# DEMETRIOU

July 31, 2017

**RE: ADU17-003, CAO1-005, DEV17-009, SHL1-007, SUB17-004 First Review Letter  
Land Use Applications for proposed home, ADU, driveway and retaining wall  
construction within a steep slope along the shoreline for the Lady Bug Trust**

**SITE SECTION AND ACCESS
EASEMENT CENTERLINE PROFILE**
THE LADYBUG TRUST
OGDEN POINT RESIDENCE
SHORELINE PERMIT PLAN
WASHINGTON
CITY OF MERCER ISLAND,

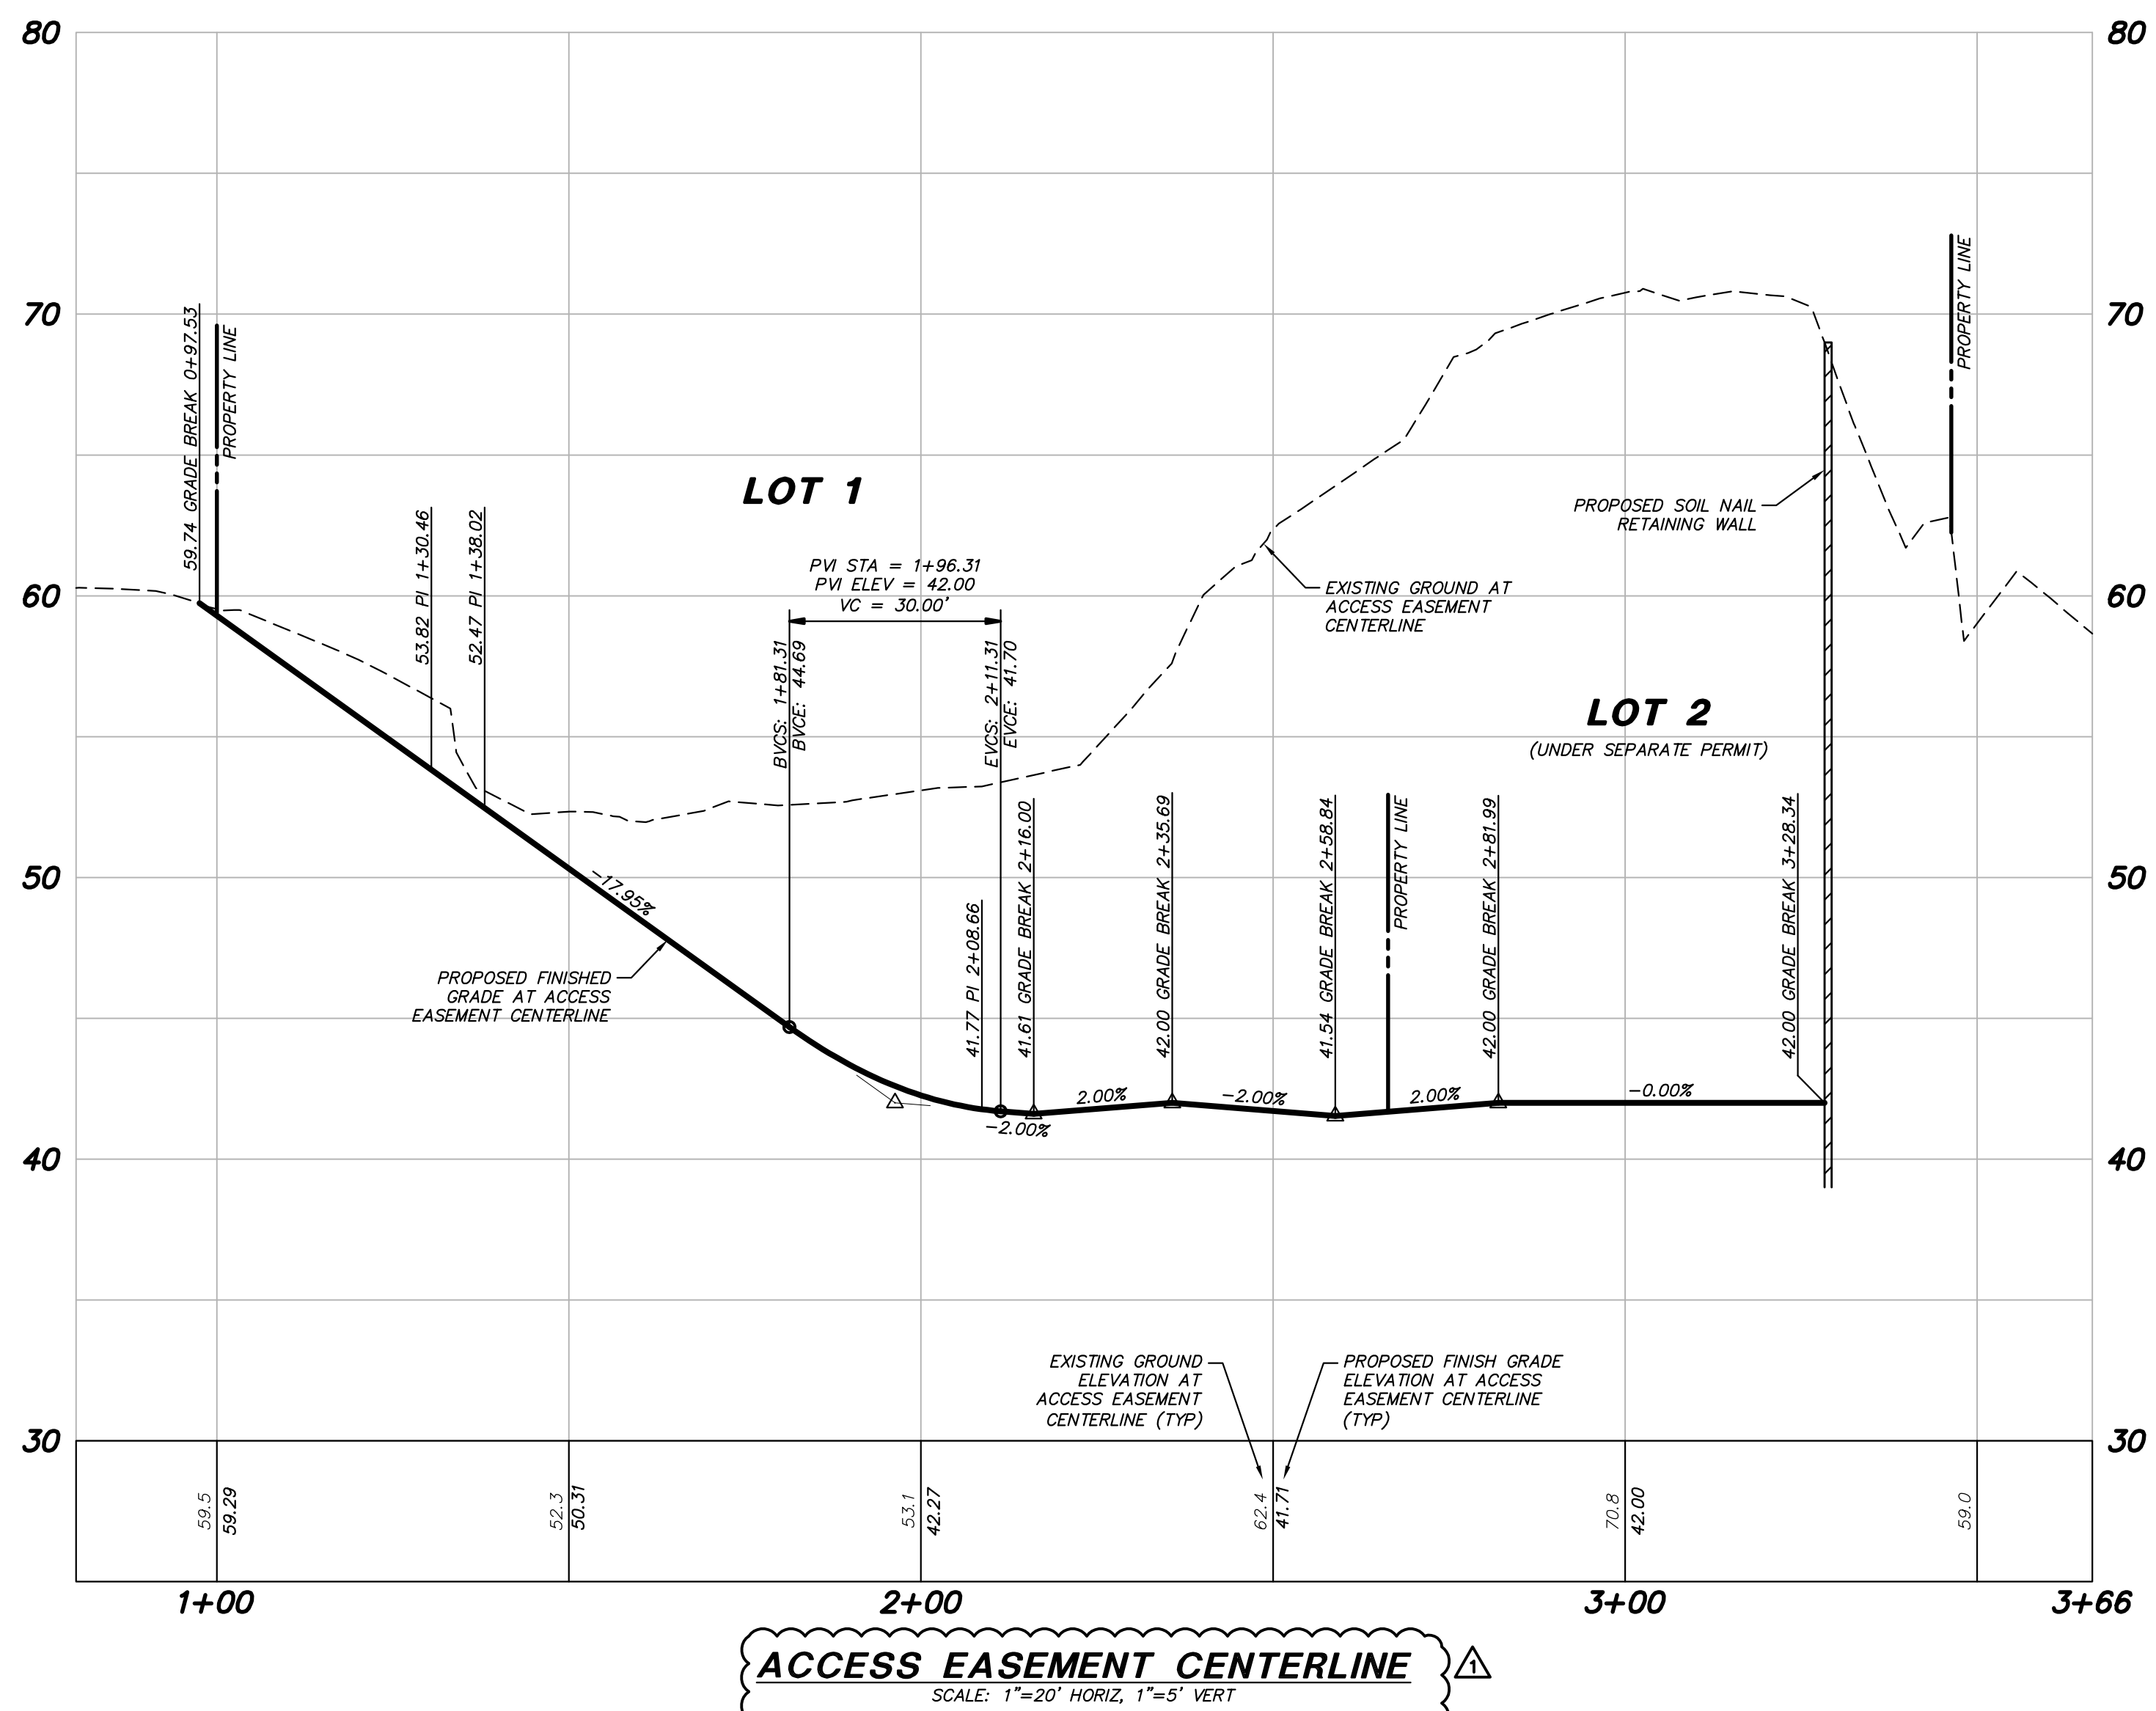
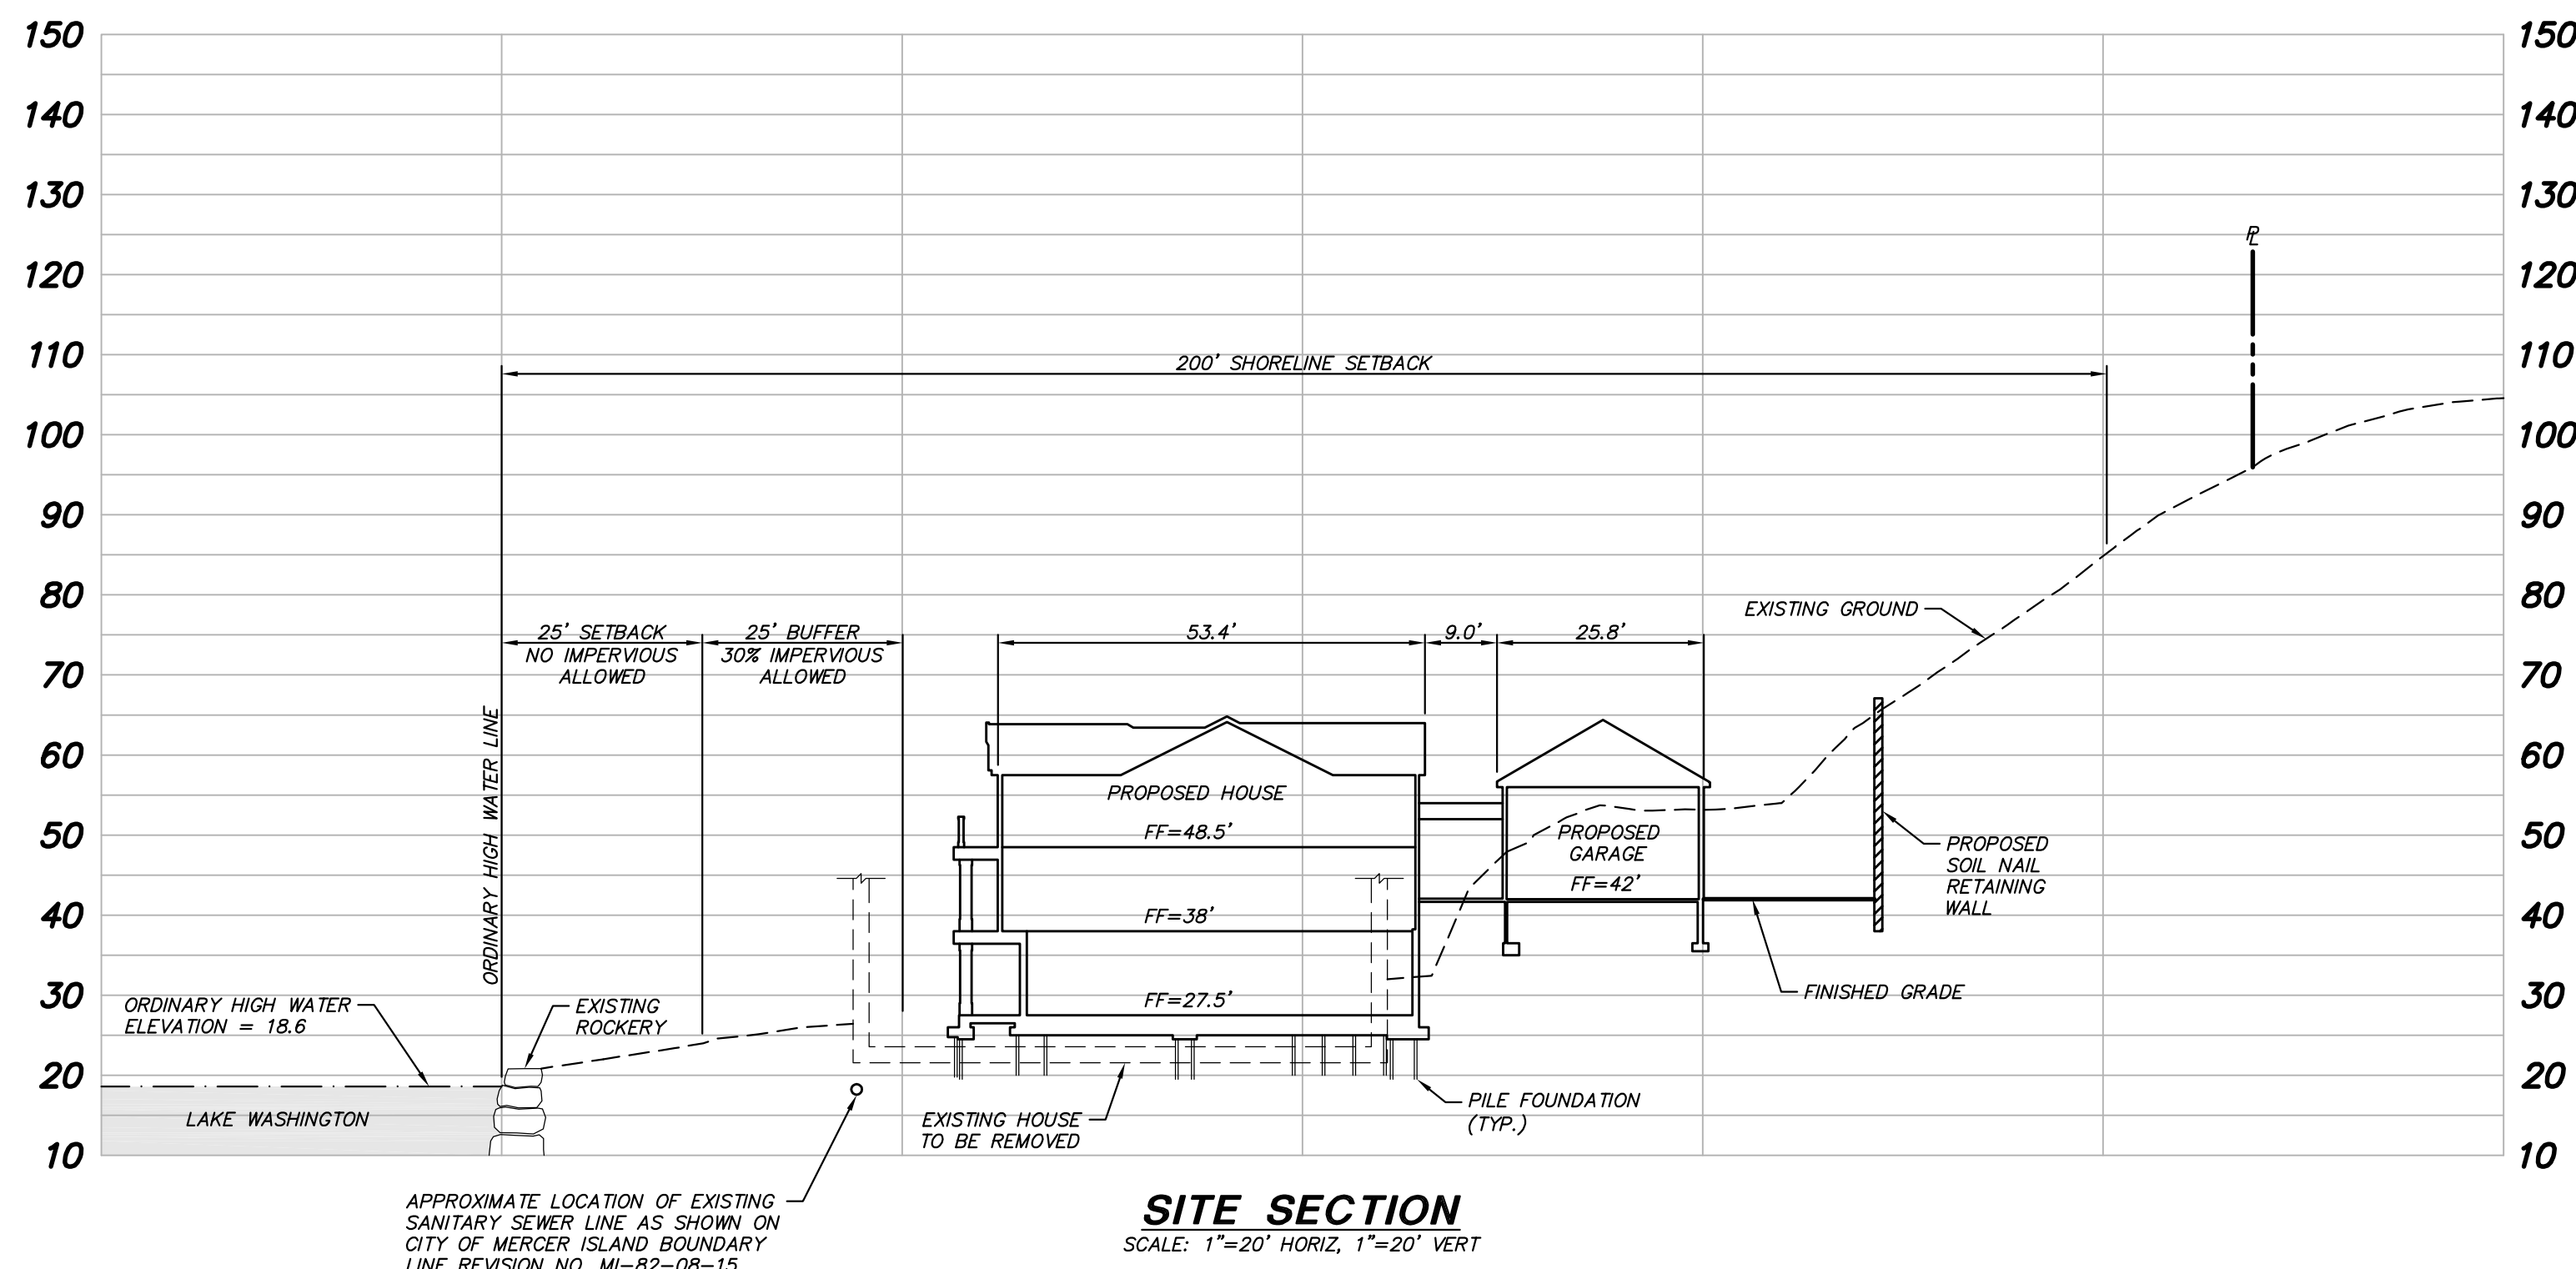
11. *Please provide a profile of the entire proposed access road on Lot 1 and including onto Lot 2. Please note that the driveway slope can't exceed 20%.*

**A profile of the proposed driveway is now shown on C2. The design has a maximum slope of 18% and uses a vertical curve transition at the base. There will be a relatively flat access to lot 2 past the initial steep section.**
